From: [REDACTED]
Sent: 05 September 2018 11:39
To: Daun Johnson
Cc: Barrie Penney
Subject: Re: Further Information Required on Your Ref: PP-07174977 Our Ref: FG/150/18/HH

As requested please find attached drawings numbers SR01 and C01 - existing and proposed floor plans.

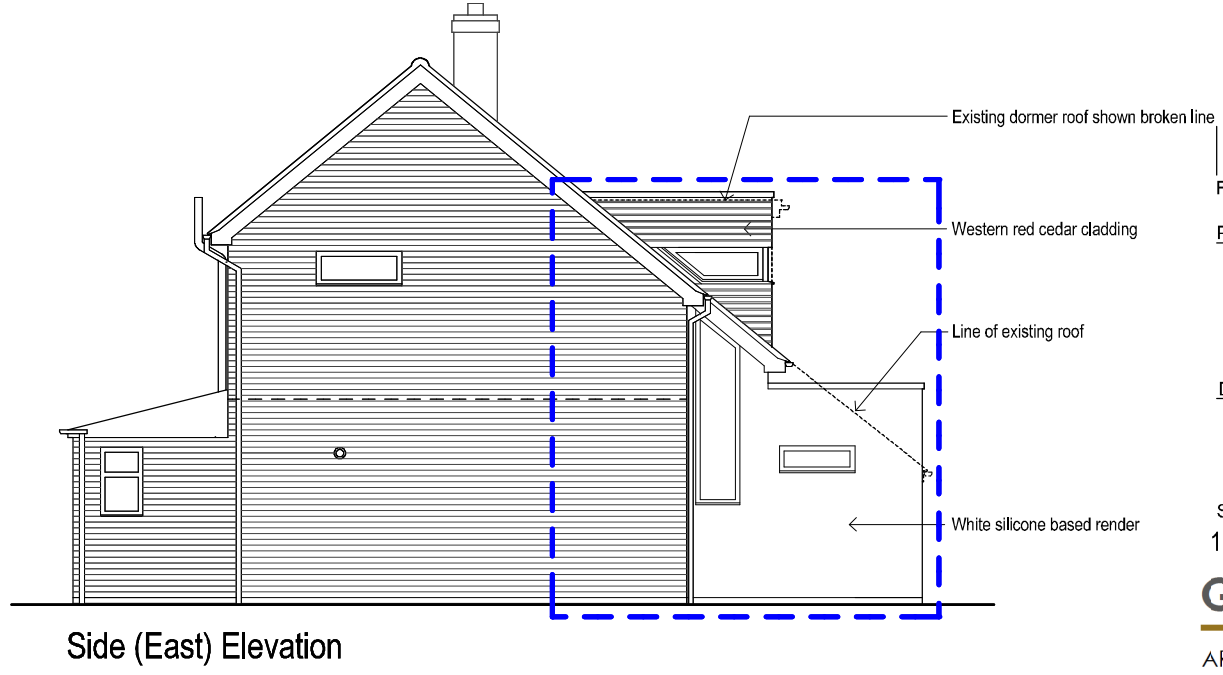
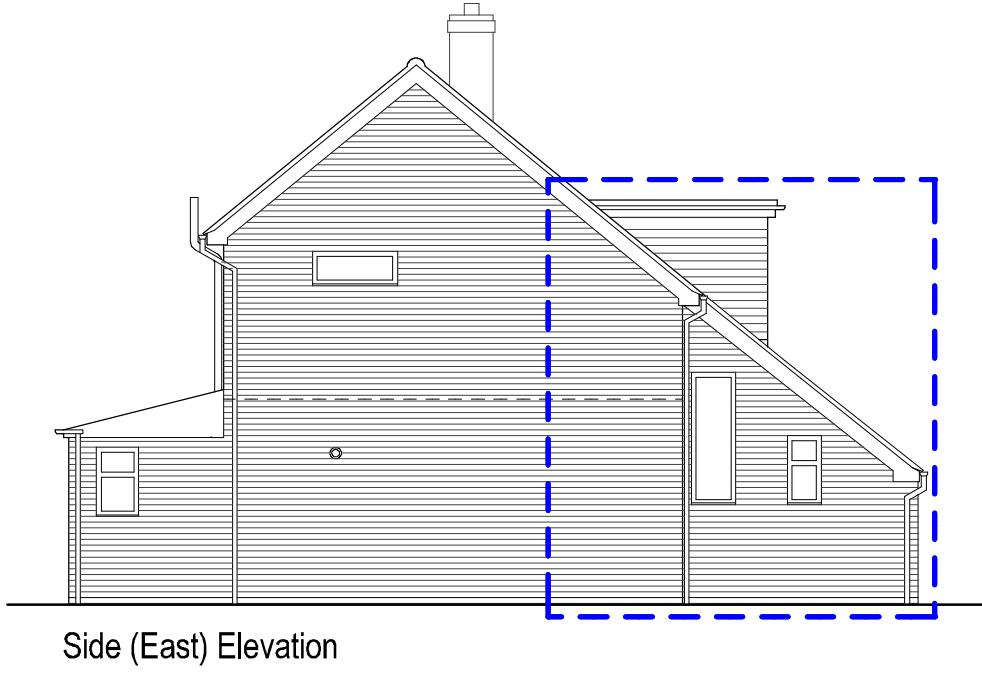
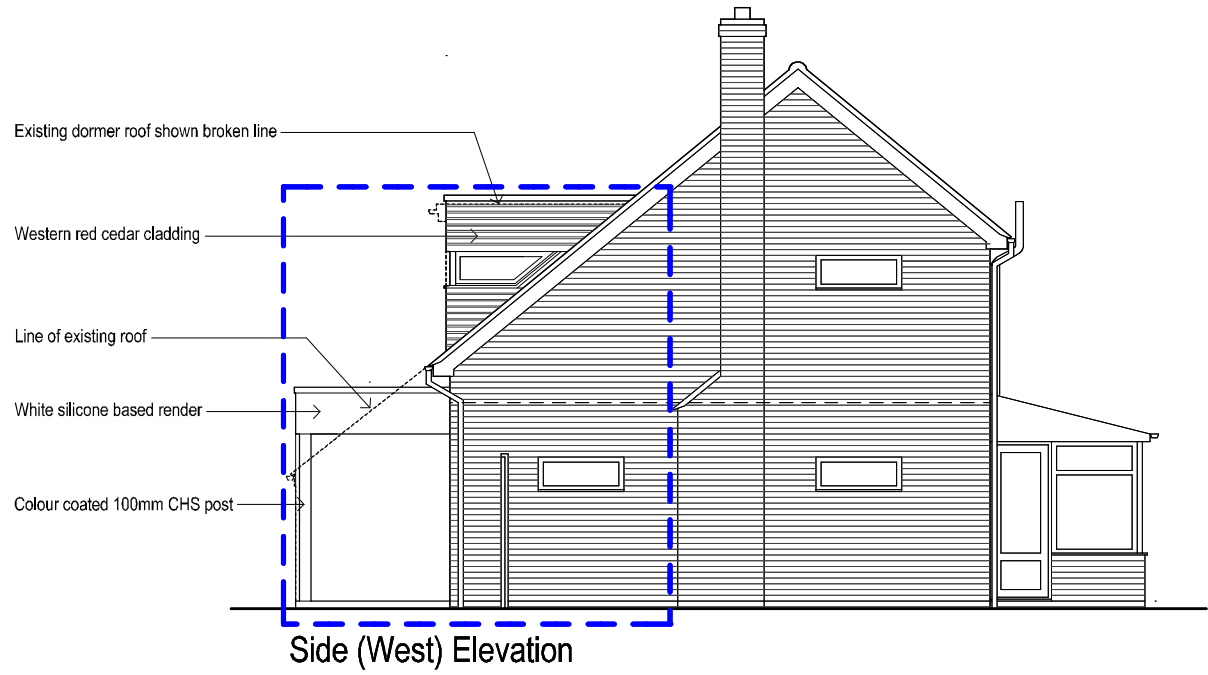
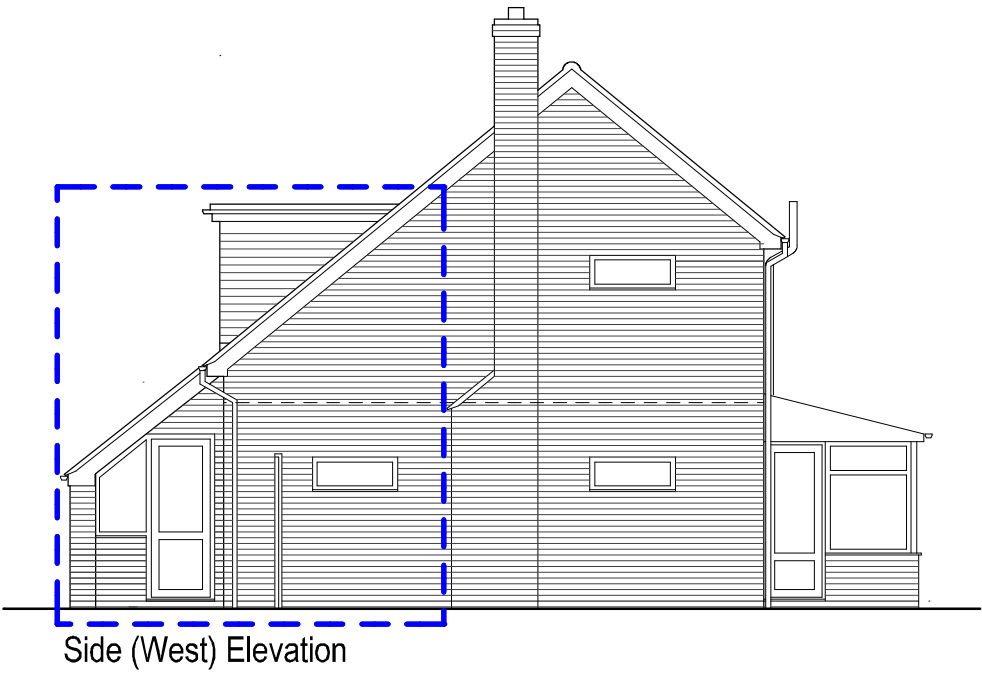
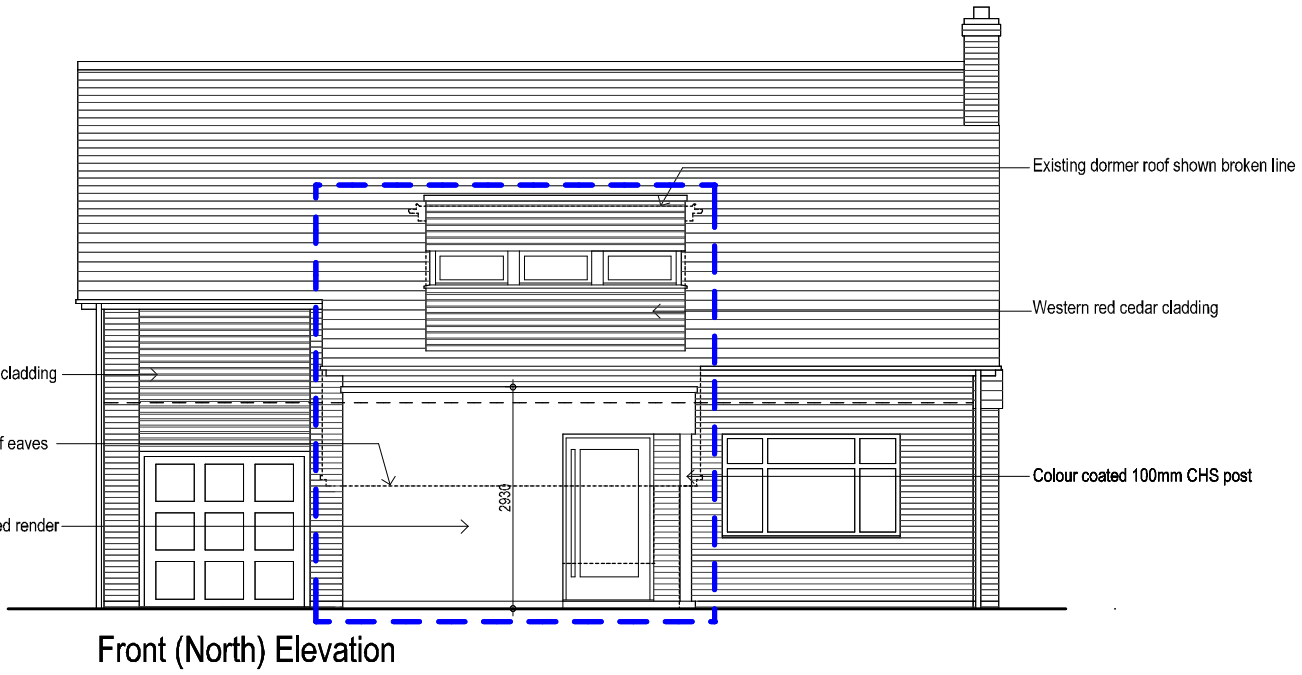
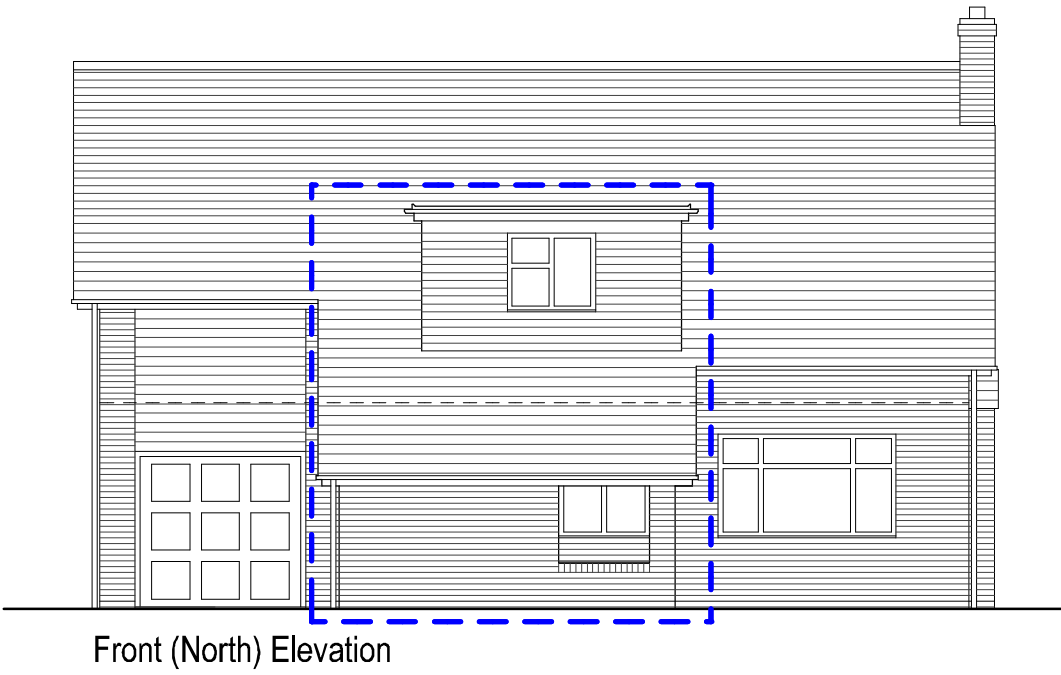
There seem to be changes in the existing and proposed floor plans/elevations concerning windows/doors. I am wondering if you consider these changes PD. If you consider the changes PD, then please clearly label the changes as PD or I can include all of the window/door changes in the description.
